Department of Public Works

Ellicott Sand & Gravel Traffic Report

Date: February 2, 2023

Updated Traffic Report provided by LSC Transportation Consultants Dated 10/20/22.

Figure 3
Proposed Primary Haul Route
 Ellicott Sand + Gravel (LSC# 194980)

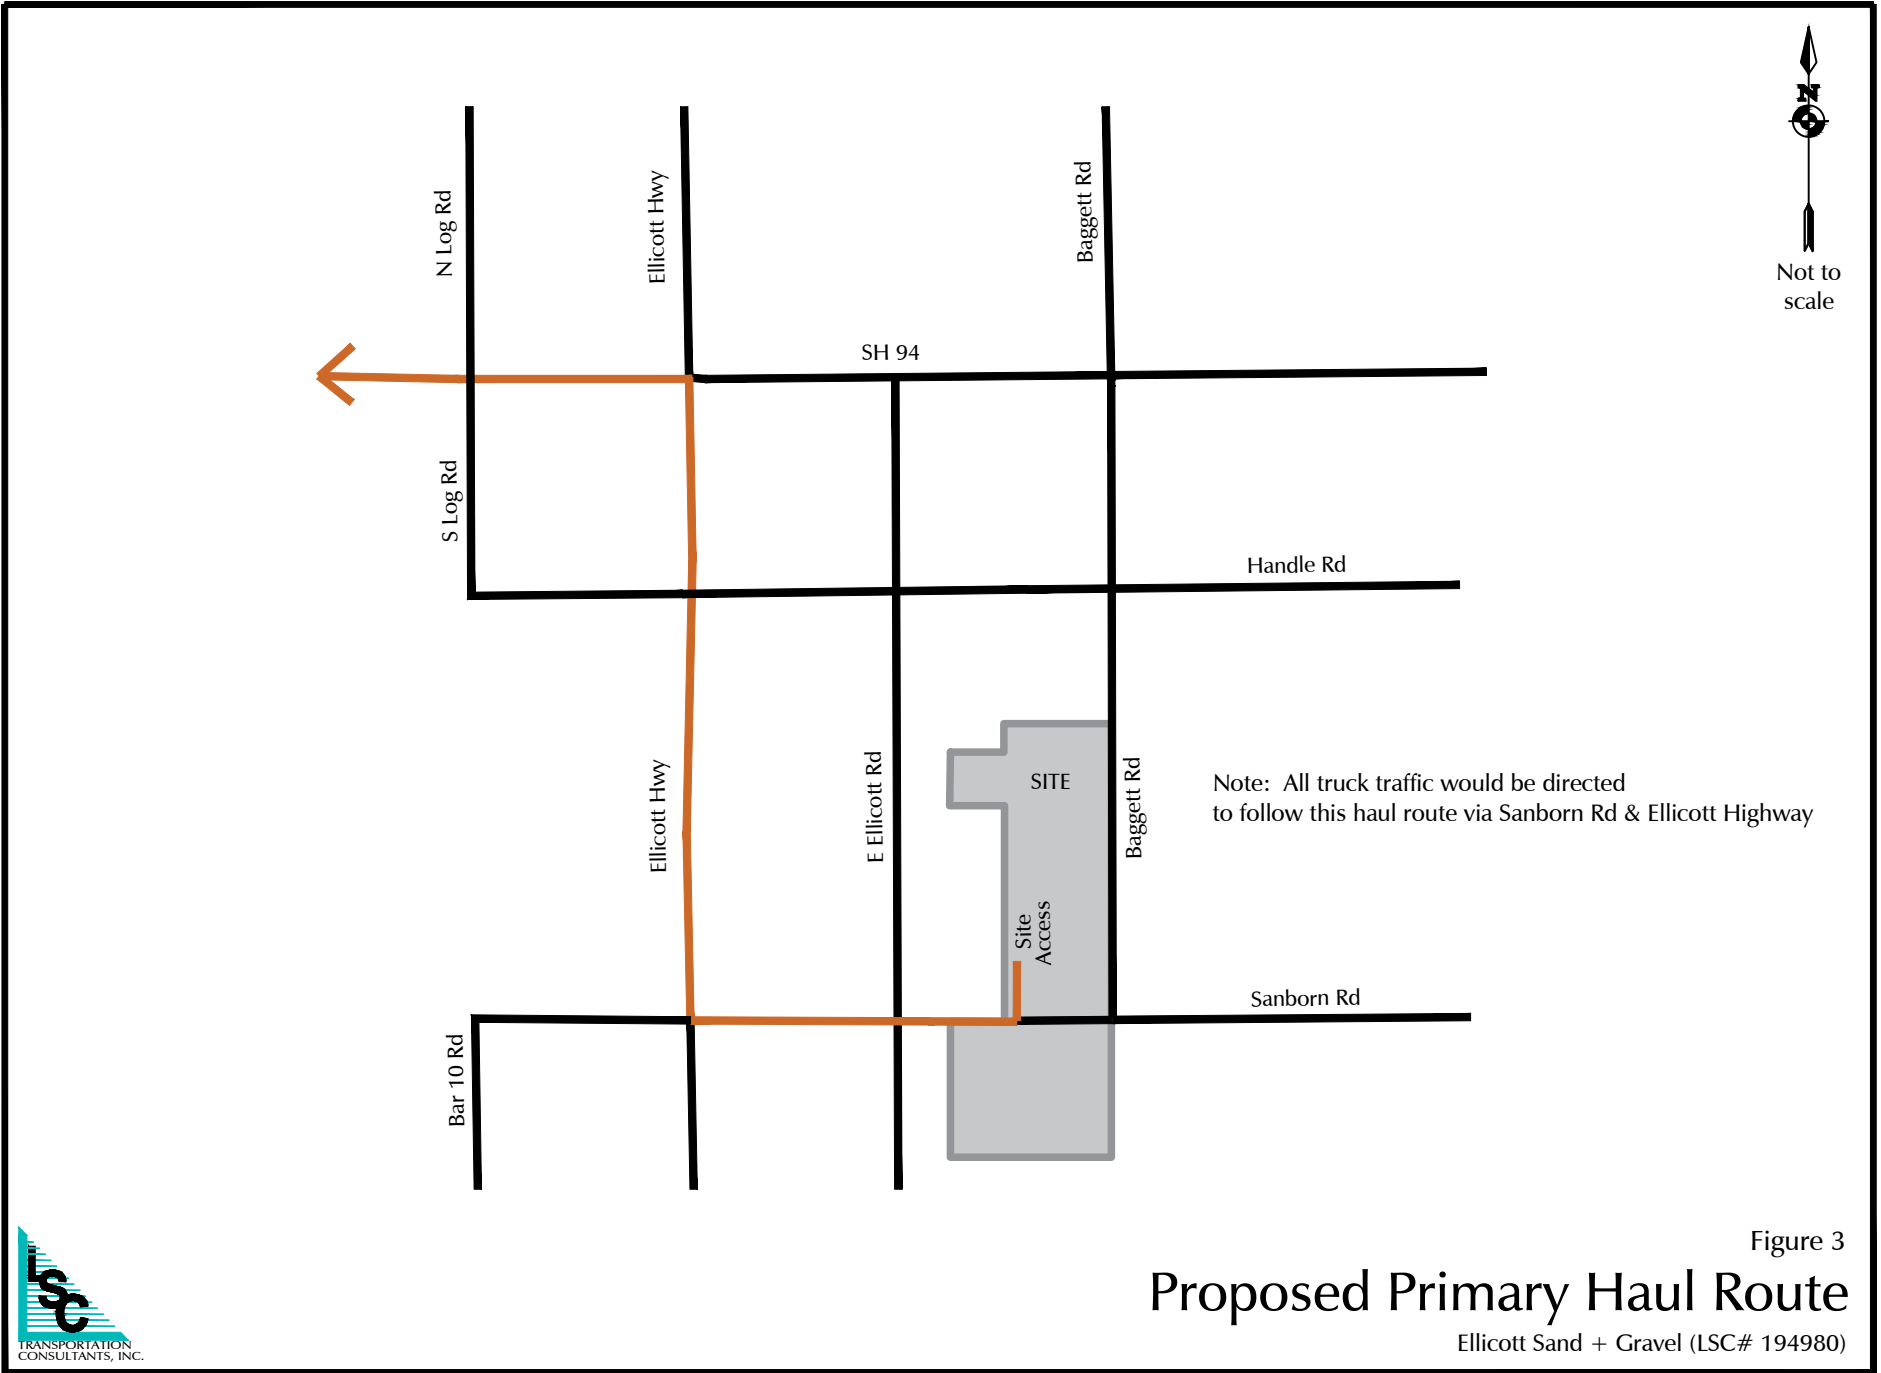
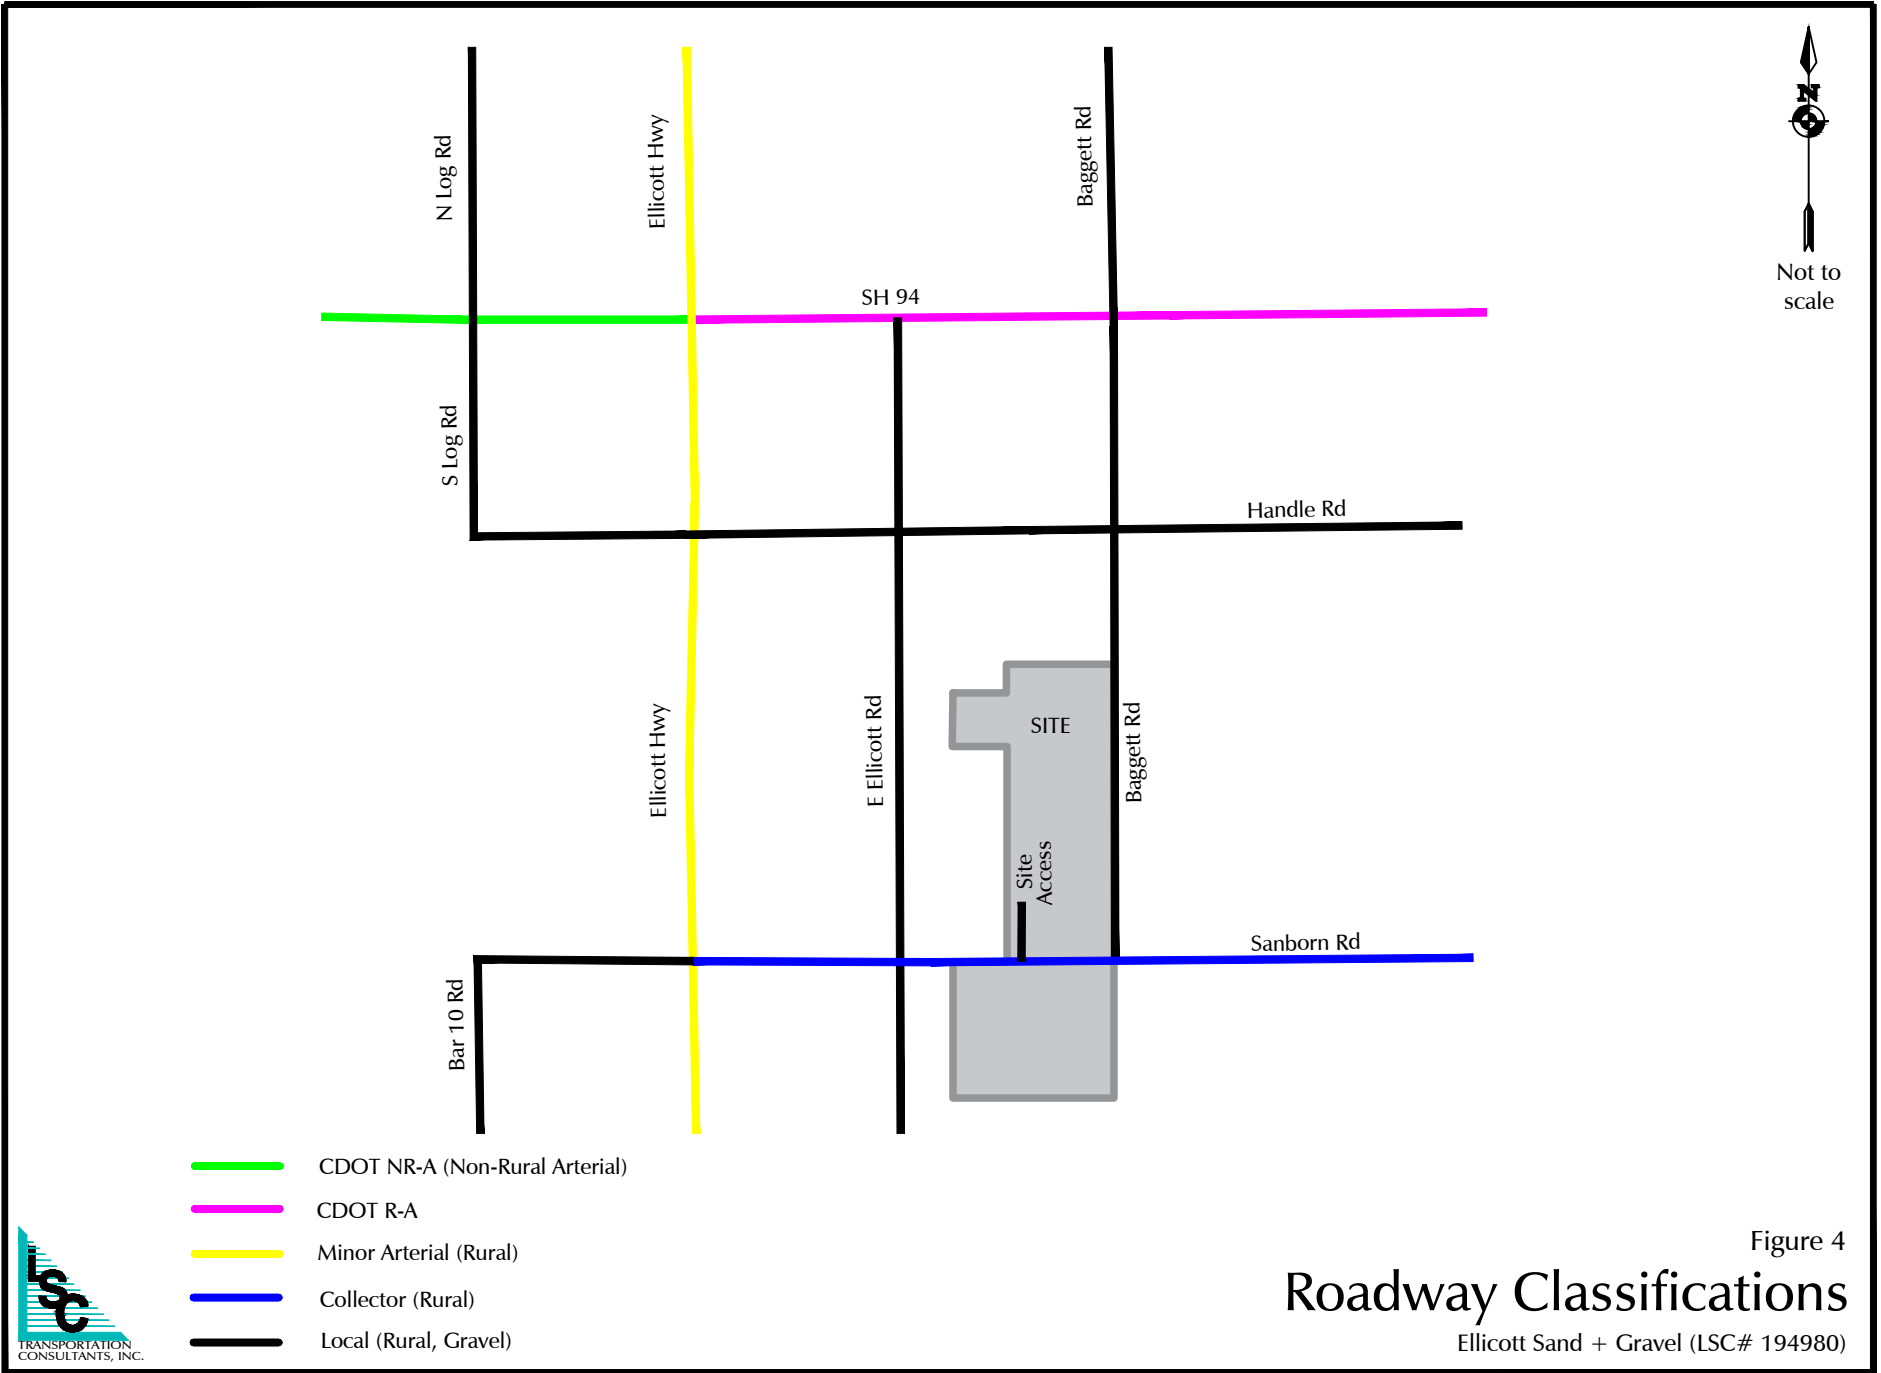
1. Originally it was proposed that the haul route would utilize Baggett Road going North to Hwy 94 from Sanborn. This route would have trucks traveling approximately 3.30 miles before reaching Highway 94. This route would impact 8 residential structures and would be conducive to future accesses from the mine to Baggett Road. Currently there is heavy truck traffic that uses Baggett almost daily coming from Shubert’s sod farm and traveling North to Hwy 94.
2. From Highway’s experience maintaining these roads, Baggett Road between Hwy 94 and Sanborn Road has superior subgrade to Sanborn Road between Baggett and Ellicott Hwy. Recently, Sanborn Road received a dust abatement treatment and new gravel layer, however due to the significant sand

3. The proposed haul route is not desirable from a trucking perspective. Trucks traveling north on Ellicott Hwy from Sanborn Road will cross over 22 residential entrances, 2 county-road intersections, a fire station, a bank, and most importantly the Ellicott School. The school has buildings on both sides of Ellicott Highway with crosswalks between for students, faculty, and others to use daily. County truck traffic is regularly routed away from this area if possible due to the heavy amounts of passenger vehicle traffic and pedestrians. The area on Ellicott Hwy near Hwy 94 gets very congested daily and is less than appealing for car traffic let alone heavy truck traffic.

Figure 5
Existing (and Future MTCP Projected) Roadway Conditions

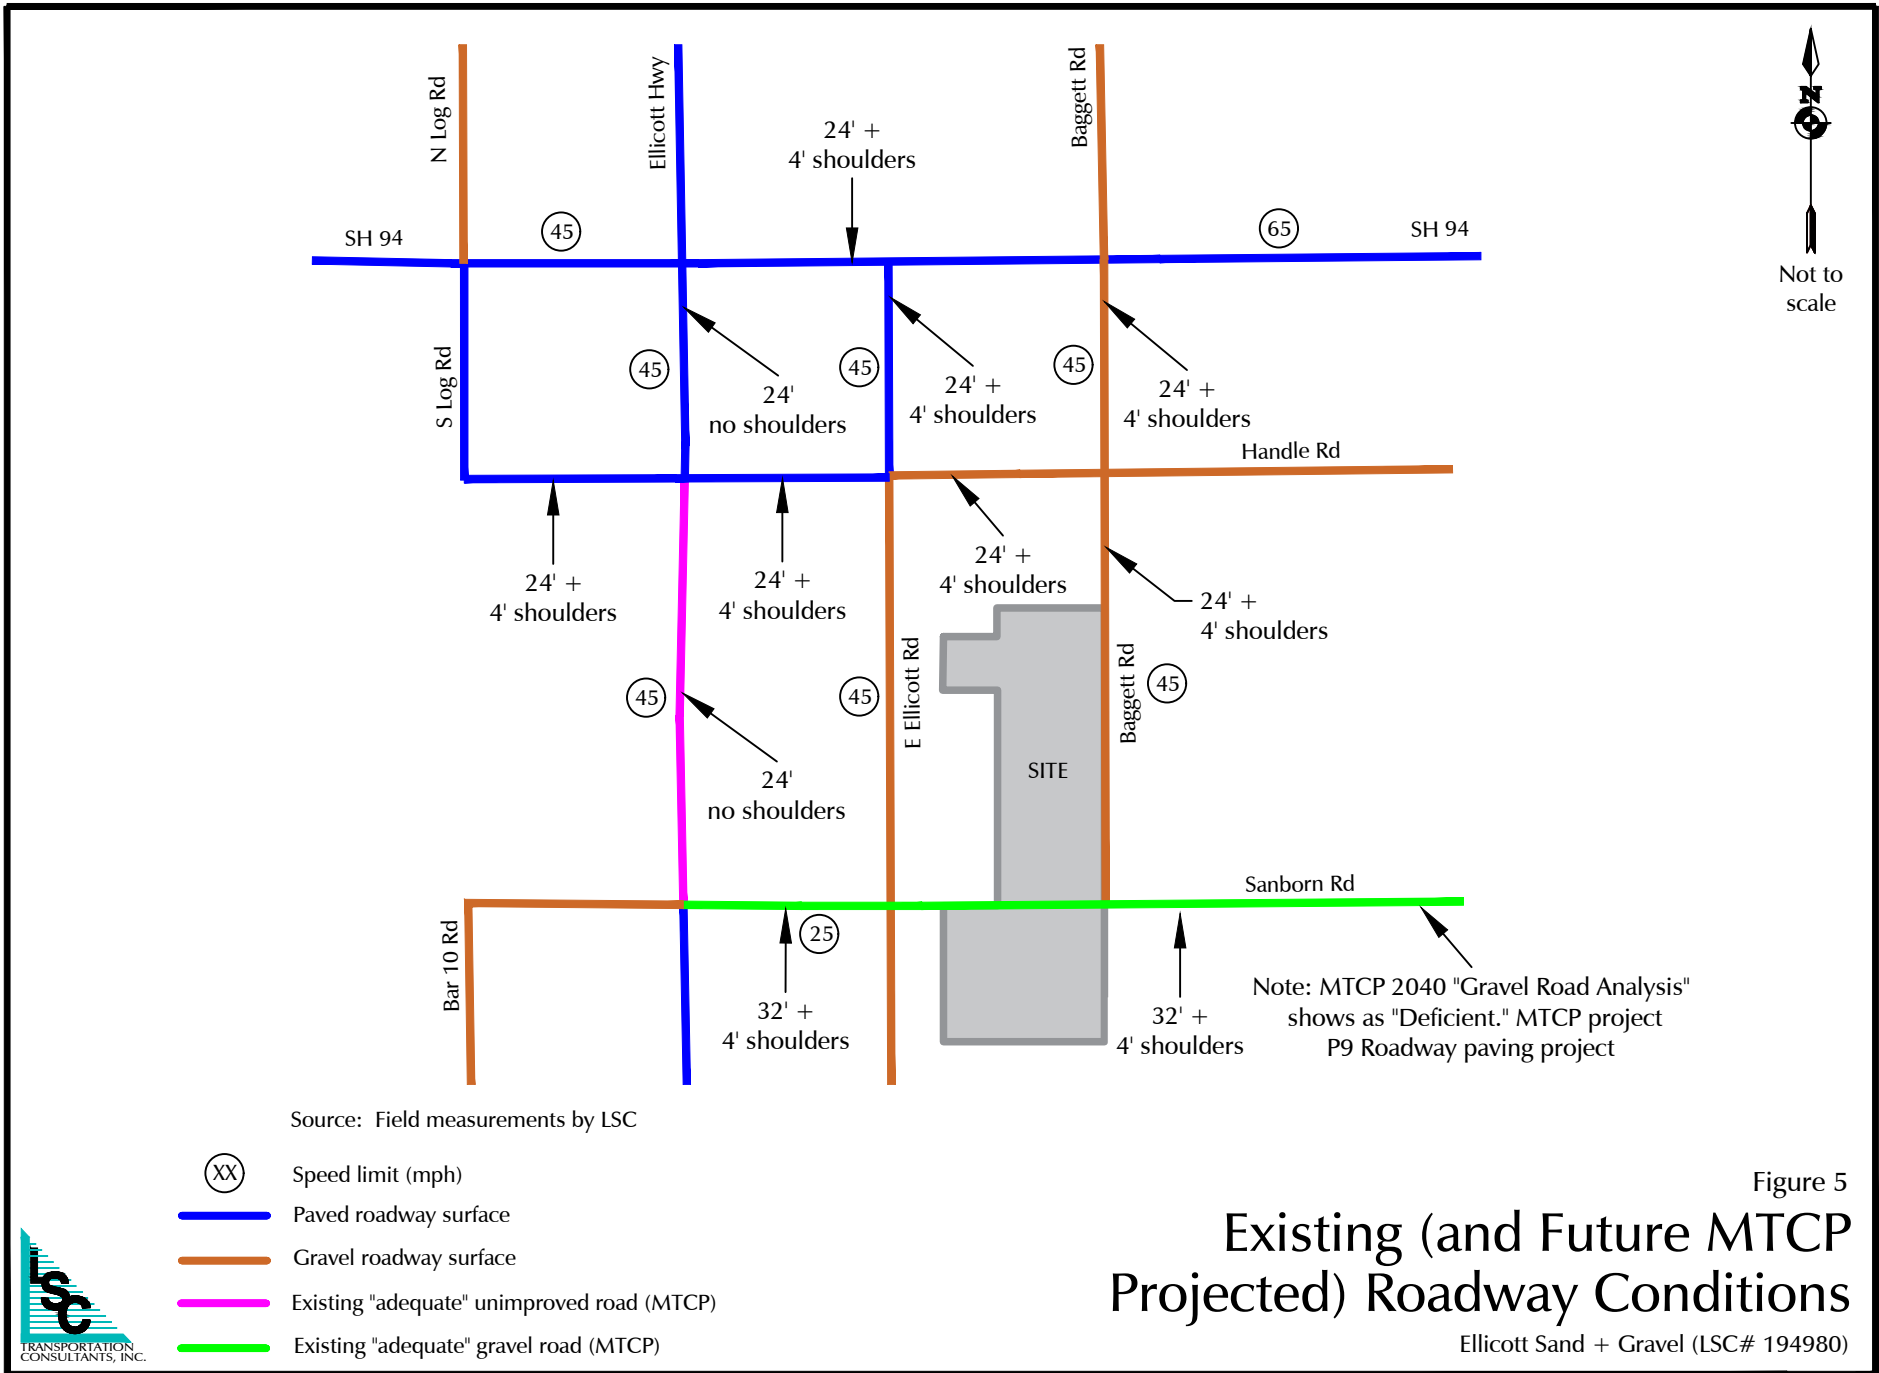
2. The study includes average daily traffic (ADT) data for roadway segments included in the haul route. For the segment of Sanborn between Ellicott Highway and Ellicott Road, ADT is shown to exceed 200, which requires conversion to a paved roadway (County ECM Section 2.2.7B.3).
